**Burke Design Group, pa**  
**Consulting Engineers**

Date: August 19, 2024  
Project: Grain Dealers Brewery  
100 N 13th St, Bay K  
Erwin, North Carolina

Comment Response:

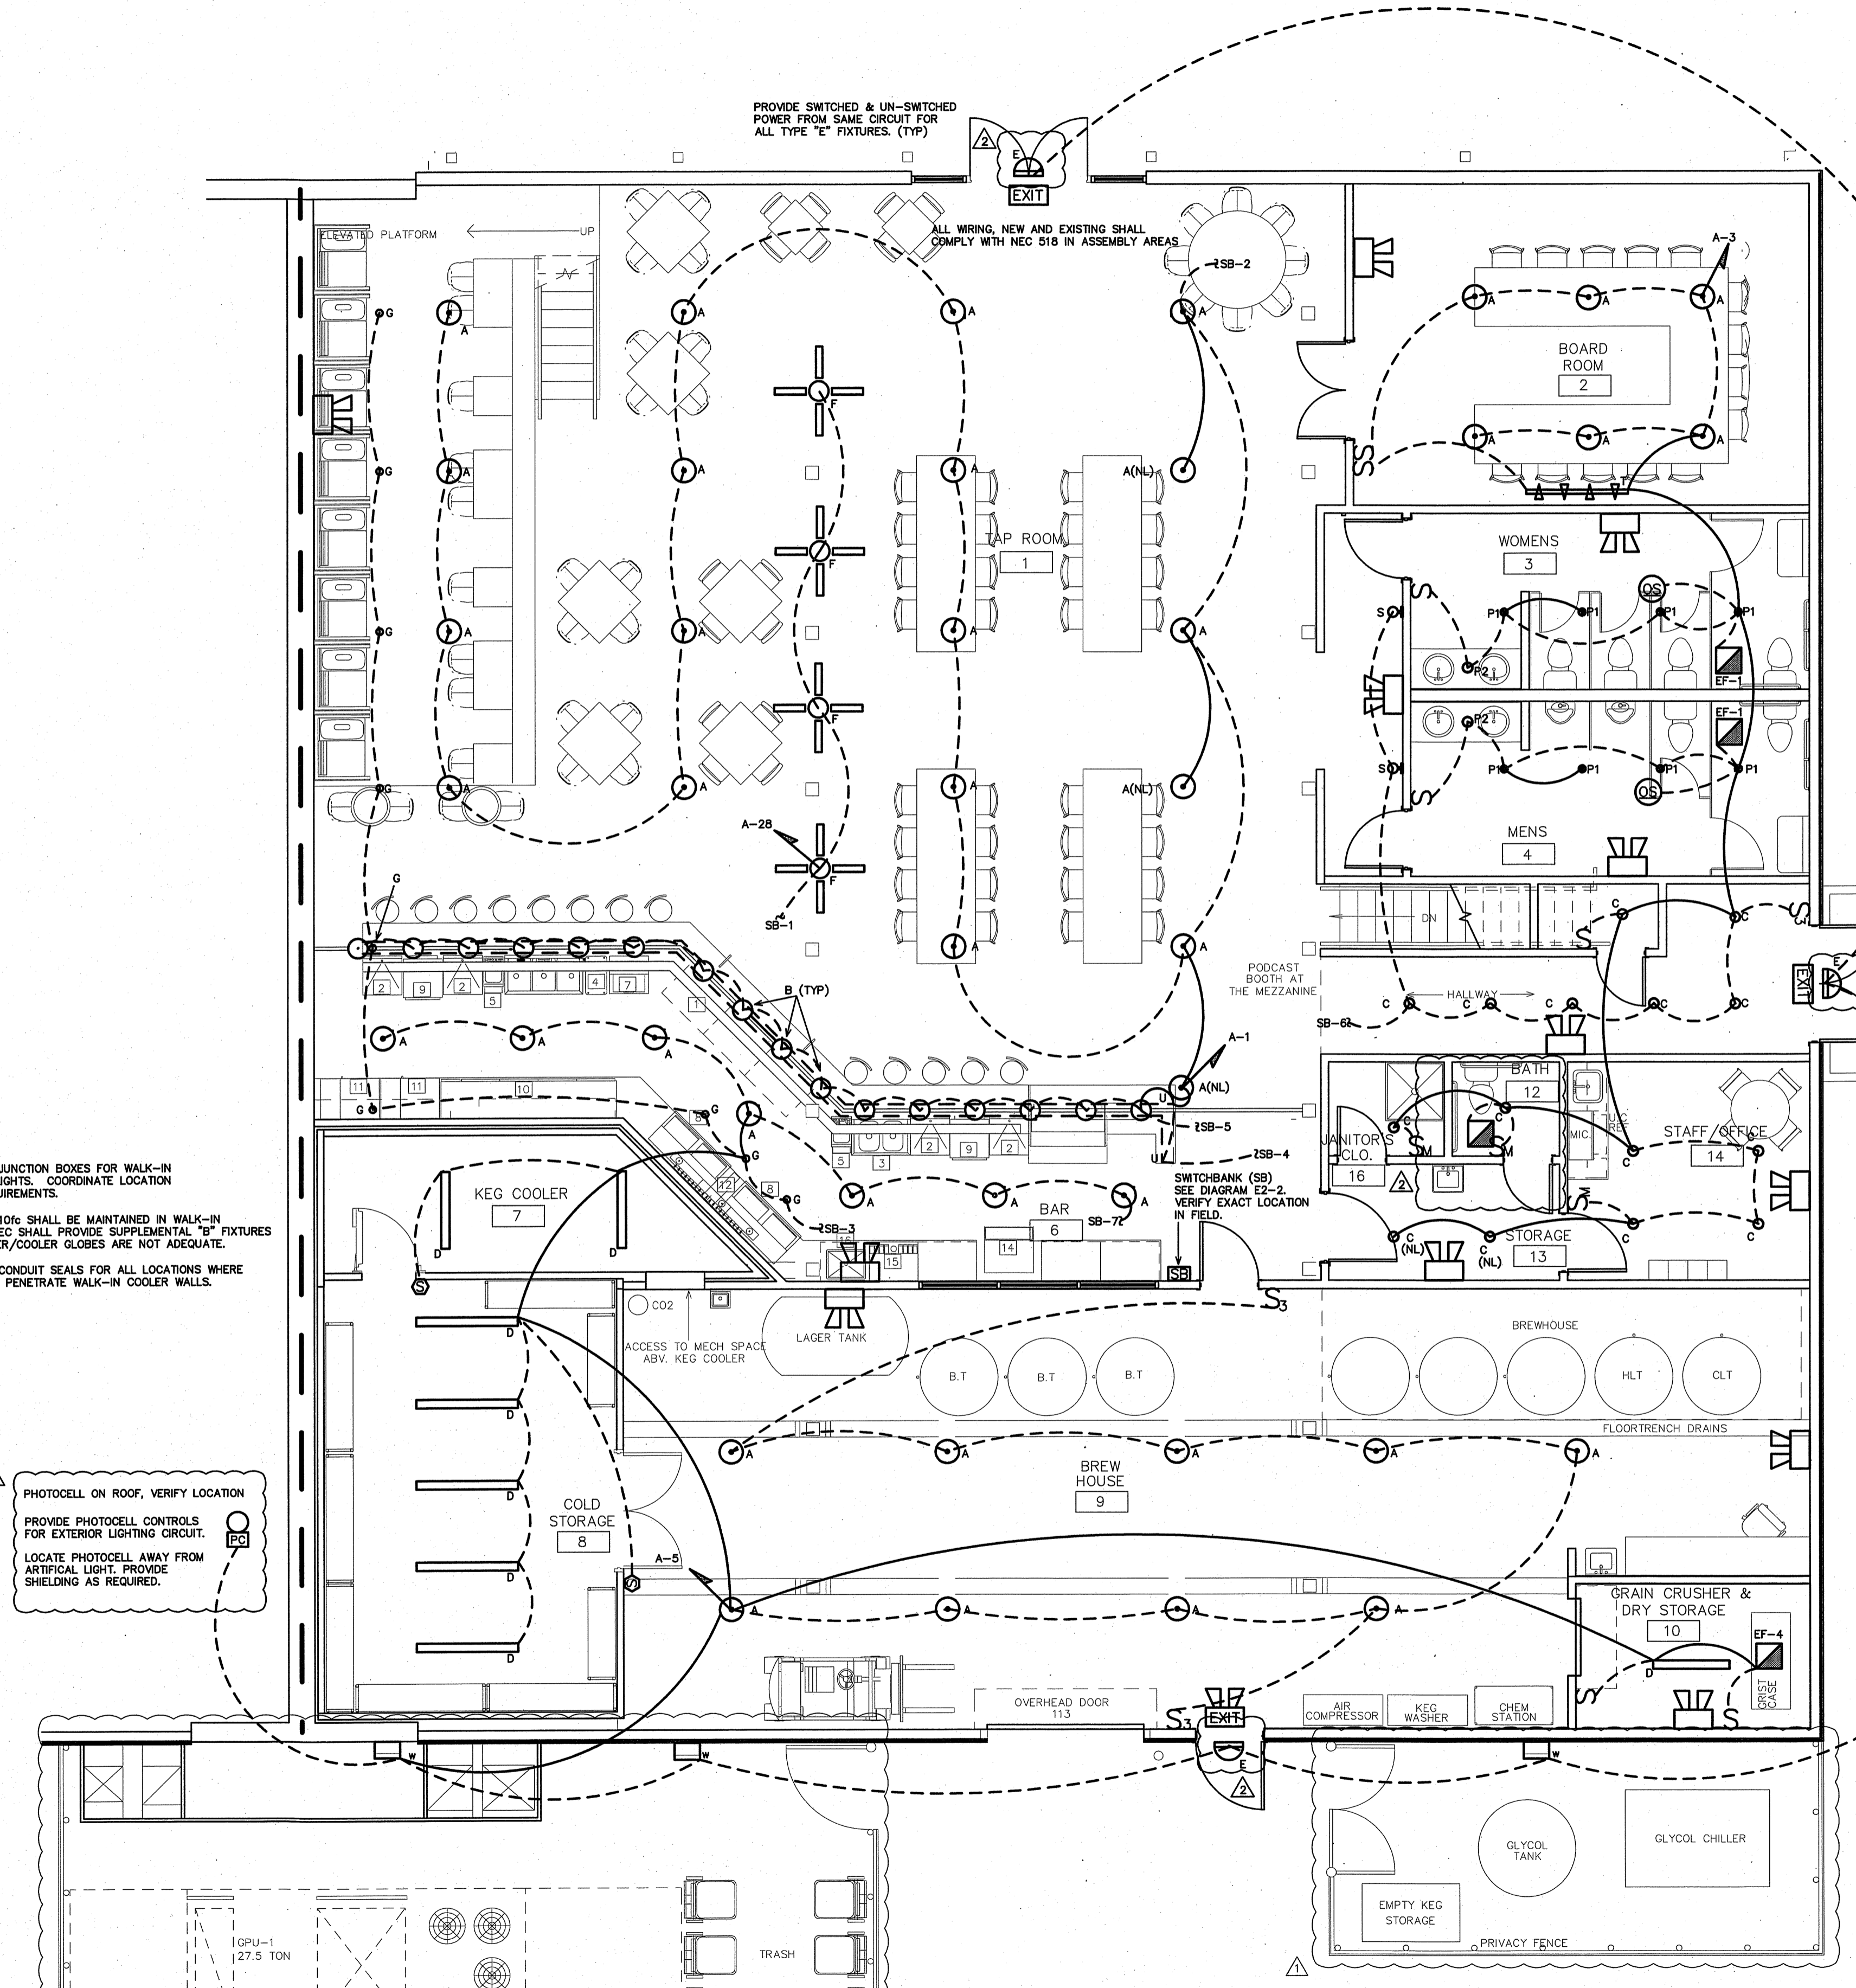
1. Need egress lighting at exterior side of egress doors (battery Backup)  
**BDG Response: Sheet E2 updated to show 'E' fixtures shifted for clarity. 'E' fixtures are emergency/normal.**
2. Lights in podcast booth shown as wall packs on ceiling? Also need emergency lighting in podcast area  
**BDG Response: Sheet E2 updated to specify 'G' fixtures in mezzanine and to show emergency lighting in podcast area.**
3. Panel A schedule shows 100A main for 400 A panel.  
**BDG Response: Sheet E4 updated to show 400A main in panel 'A'**
4. Circuit 2 from main disconnect to first panel "m" does not show a neutral.  
**BDG Response: Sheet E4 updated to revise riser wiring**
